Our Reference: SYD16/01626
Department Ref: SSD 8114

LINDFIELD LEARNING VILLAGE - 100 ETON ROAD, LINDFIELD

Roads and Maritime has reviewed the submitted application and does not support the development in its current form and provides the following comments for consideration:

Drawing Title  
 Turning Paths  
 For Bushfire Cat 1 Tanker

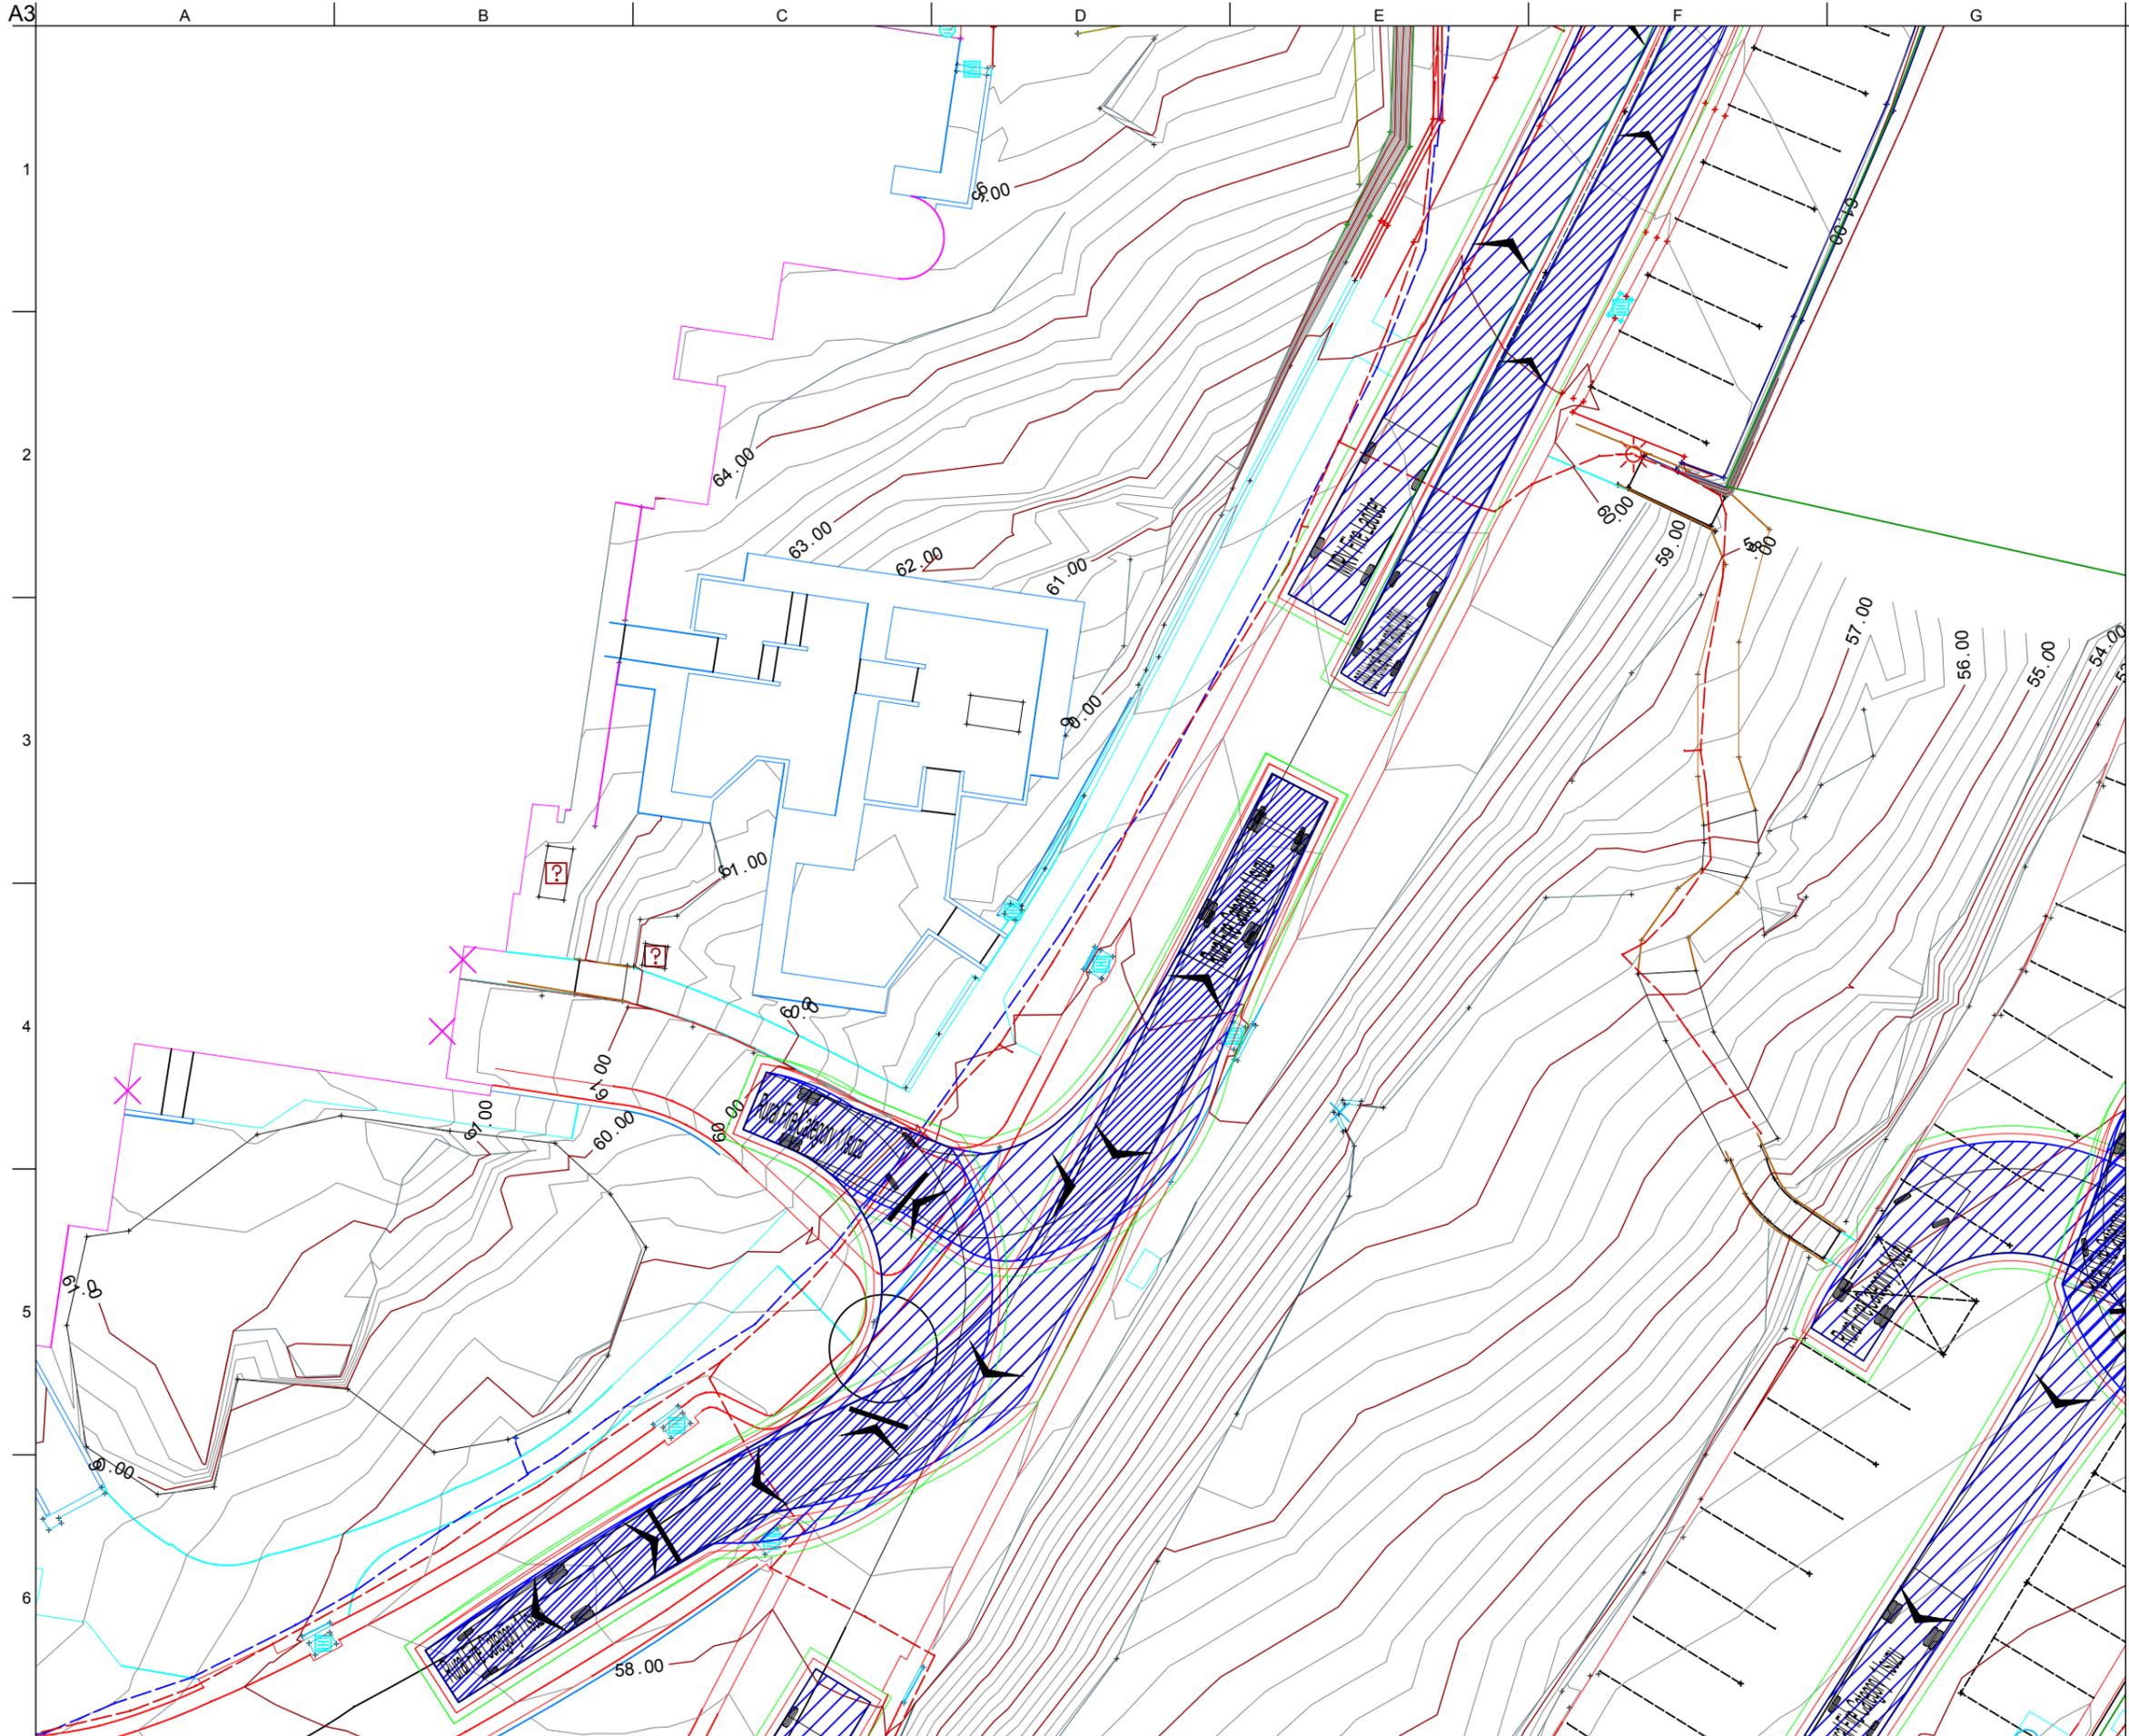
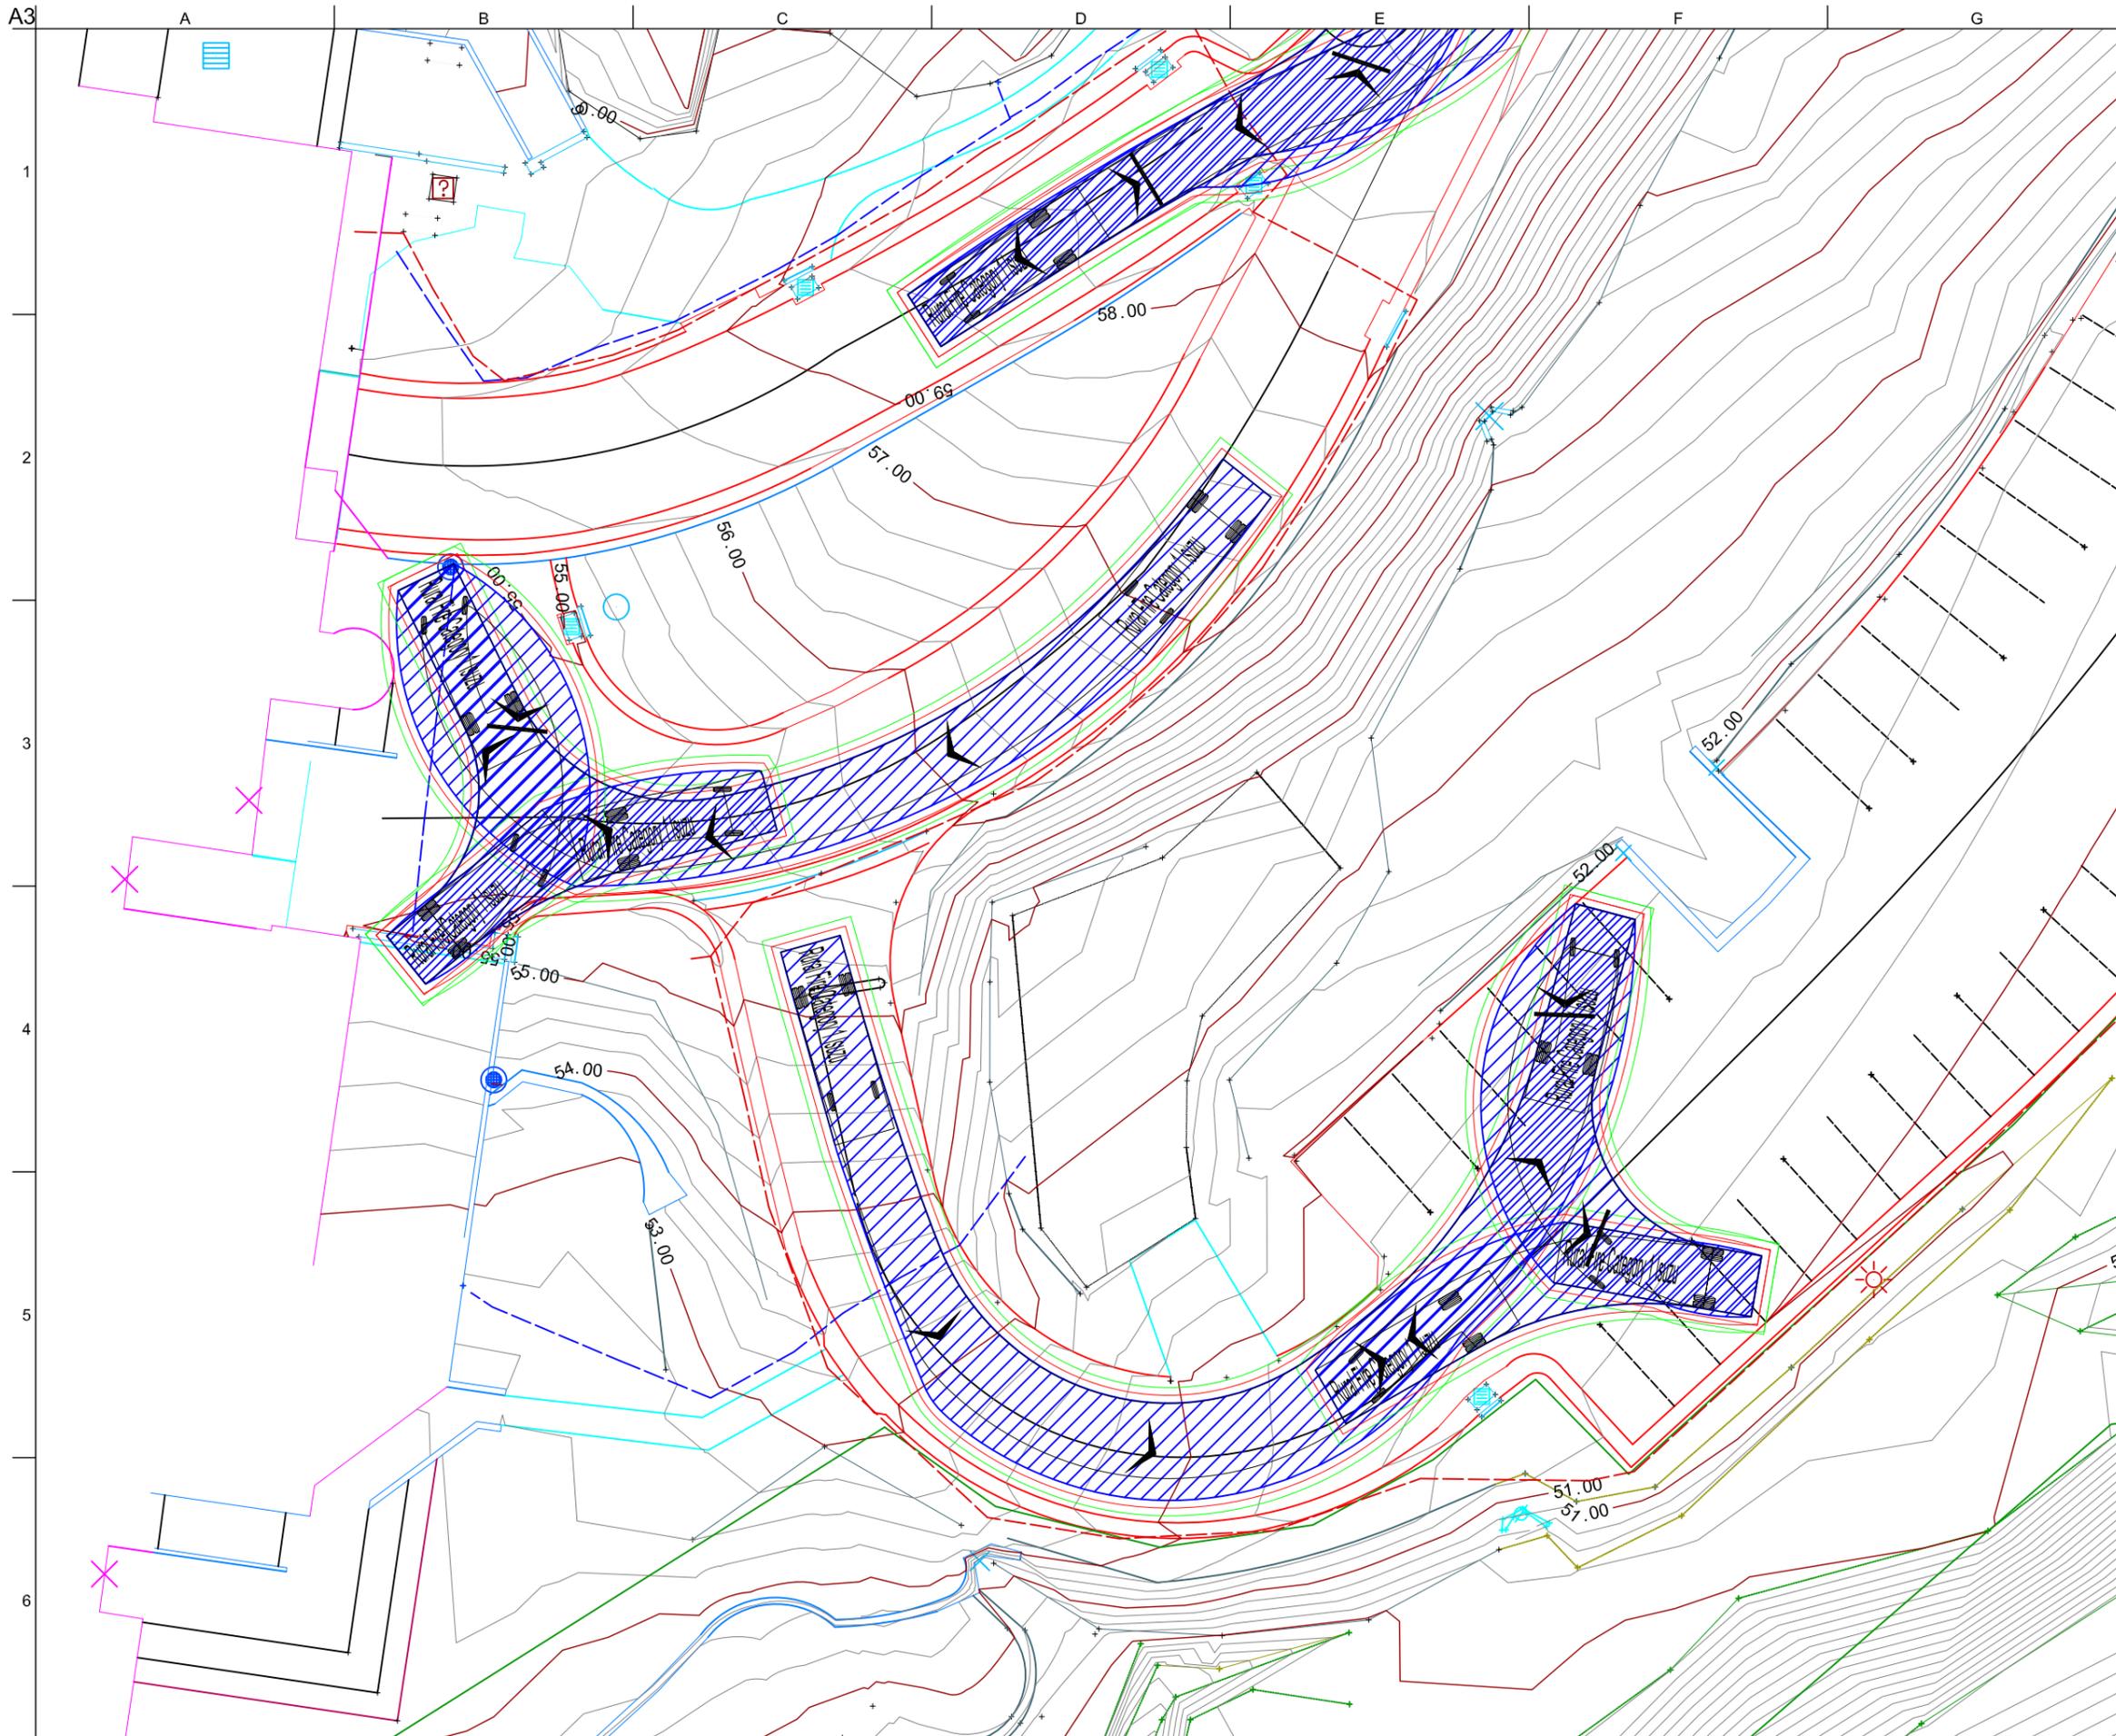
1. Given the narrow nature of the Eton Road access to the campus/school grounds, Roads and Maritime requires clarification regarding emergency vehicle access in emergencies.
